Rezoning Transportation Analysis

Petition Number: 2021-130

From: Brandon Brezeale, PE
Brandon.Brezeale@charlottenc.gov
704-432-5561

Date	Description
09-15-21	First Review (BKB)

**RZ1.0**

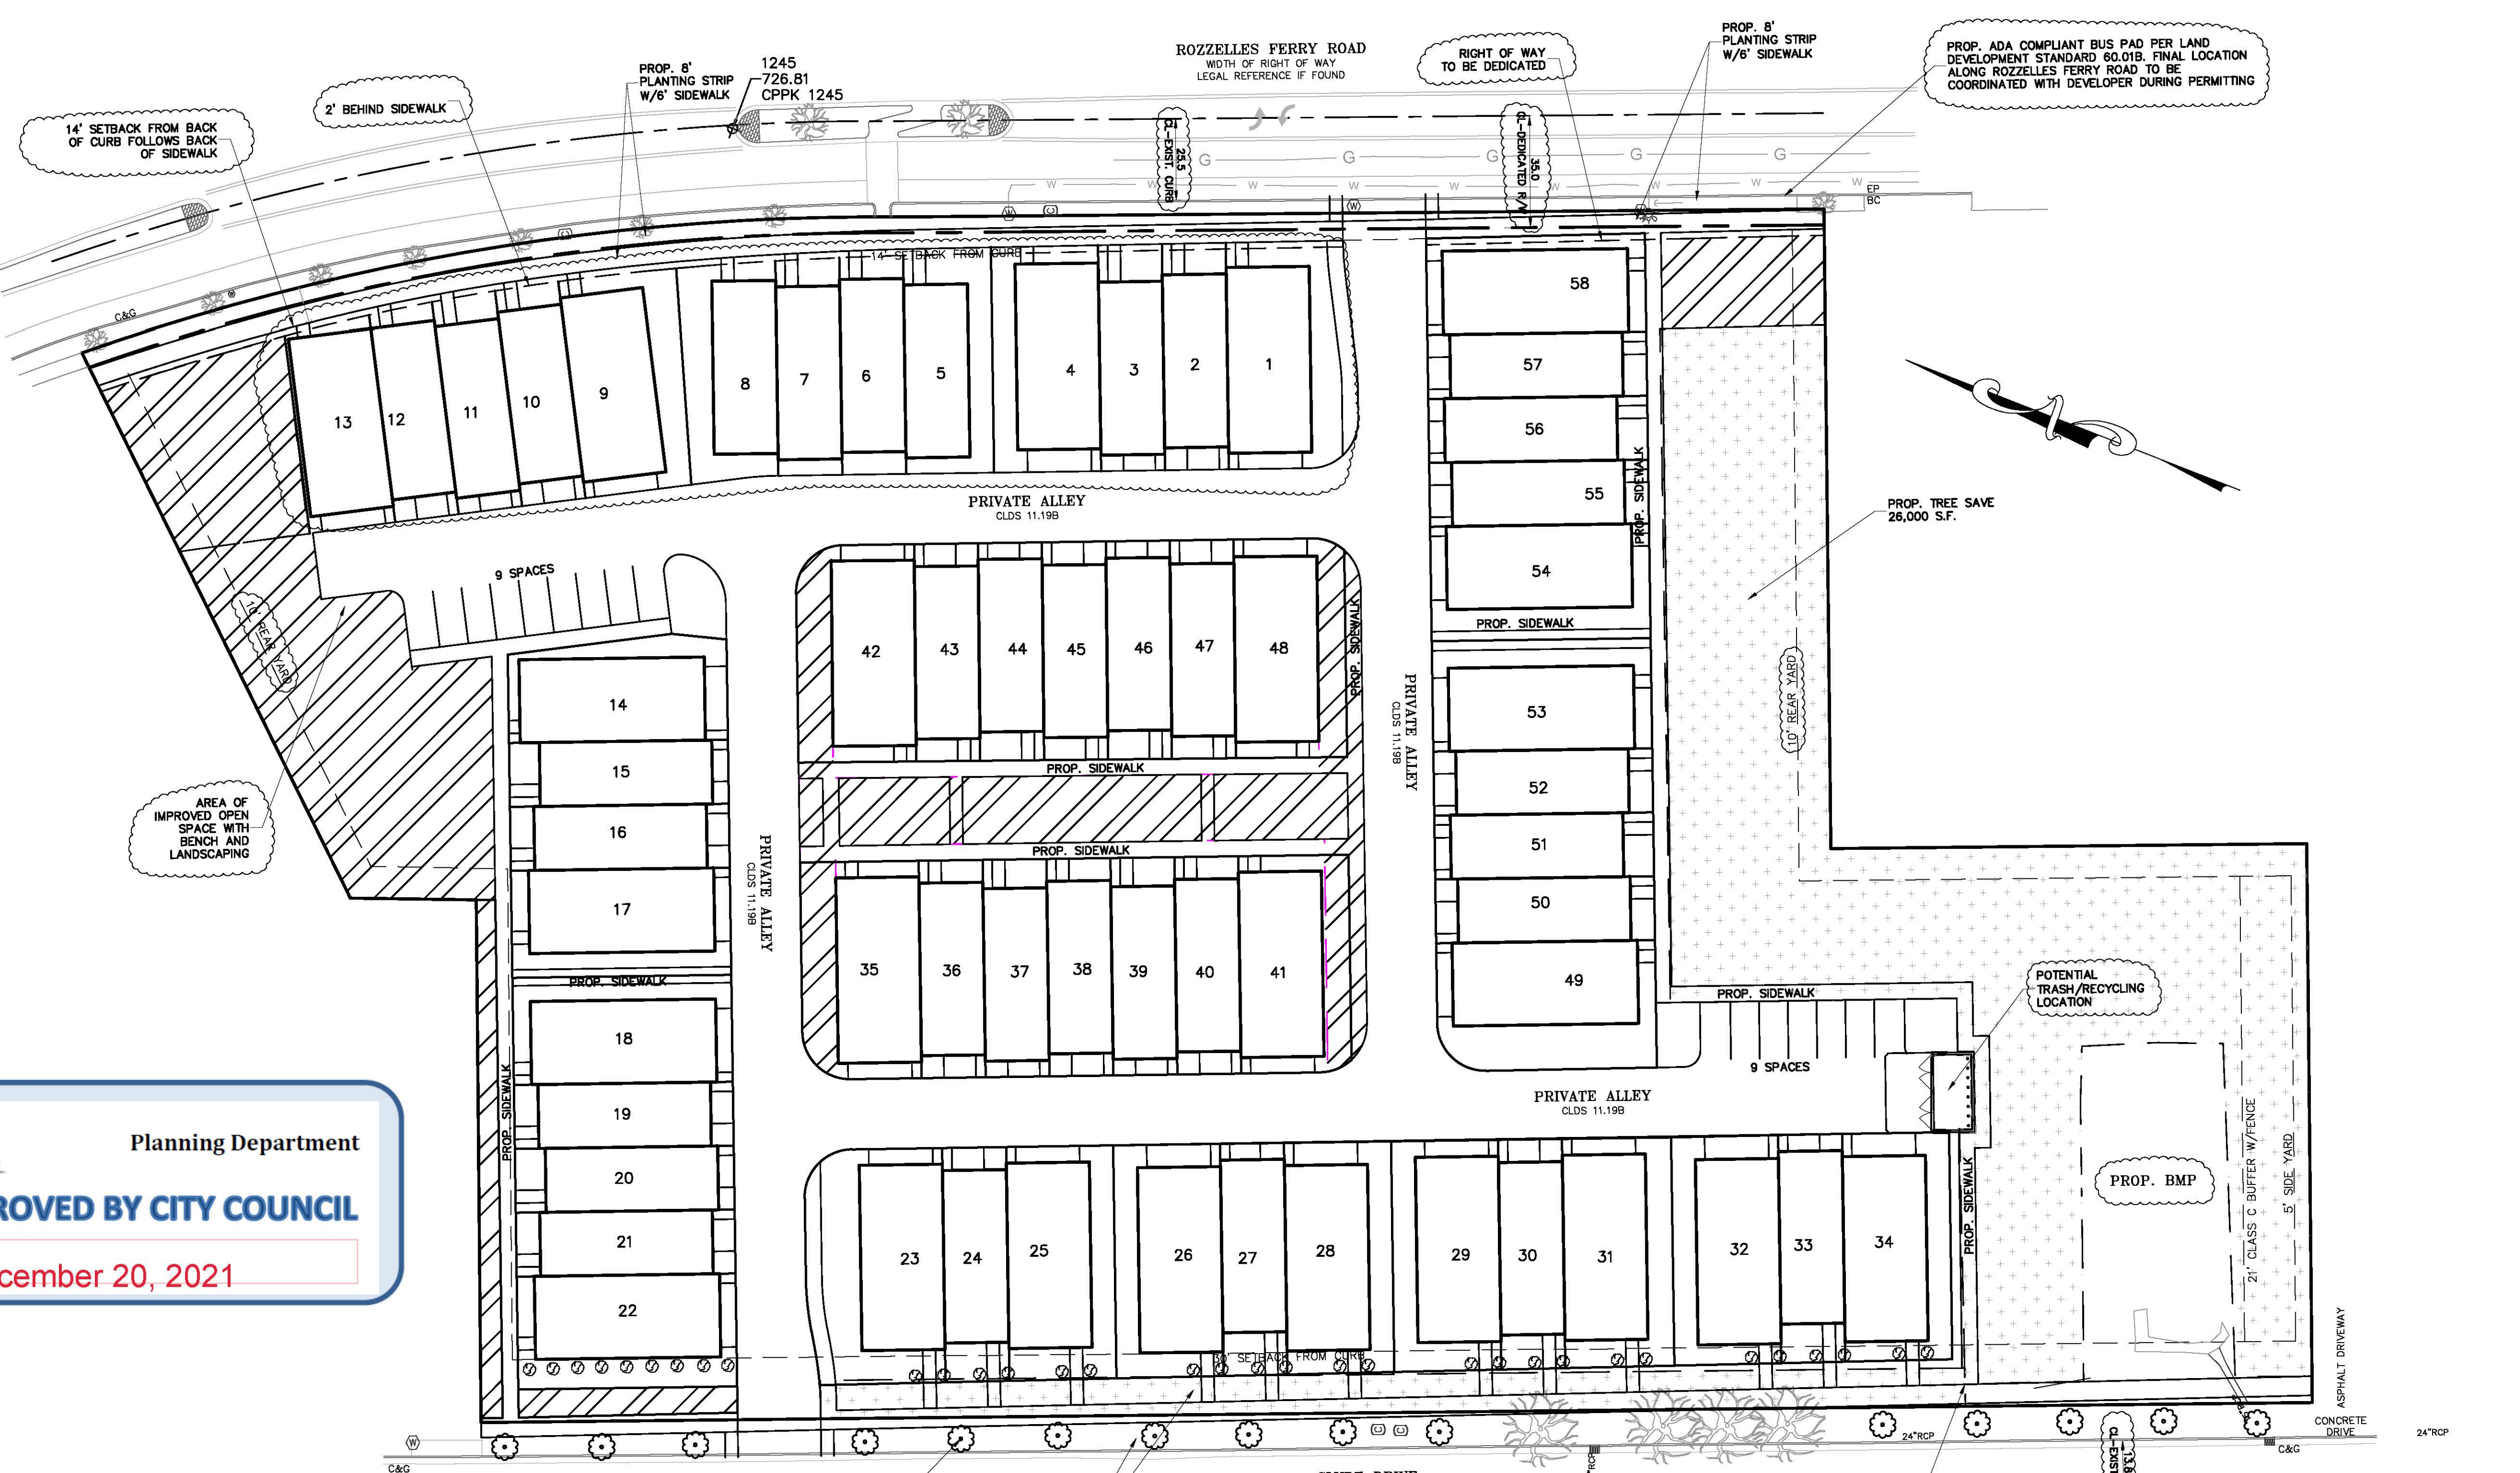
- Curbline:** The proposed zoning district has a setback measured from back of the existing curbline.
 - Label and dimension the curb and gutter from the centerline for each road on the site plan.
- Traffic Study:**

- Revise site plan and conditional note(s) to commit to dedicate 35-foot right-of-way from the road centerline on Rozzelles Ferry Road. The site plan shall label and dimension the right-of-way from the road centerline.

- Revise site plan to include labels for all internal streets as "Private Alley" and reference CLDSM 11.19B.
- A site plan note(s) specifying dedication and fee simple conveyance of all rights-of-way to the City before the site's first building certificate of occupancy is issued. CDOT requests rights-of-way set at 2' behind back of sidewalk where feasible.

- A site plan note specifying that all transportation improvements will be approved and constructed before the site's first building certificate of occupancy is issued is needed. The petitioner may phase transportation improvements if said improvements and phasing are explicitly described in site plan notes.
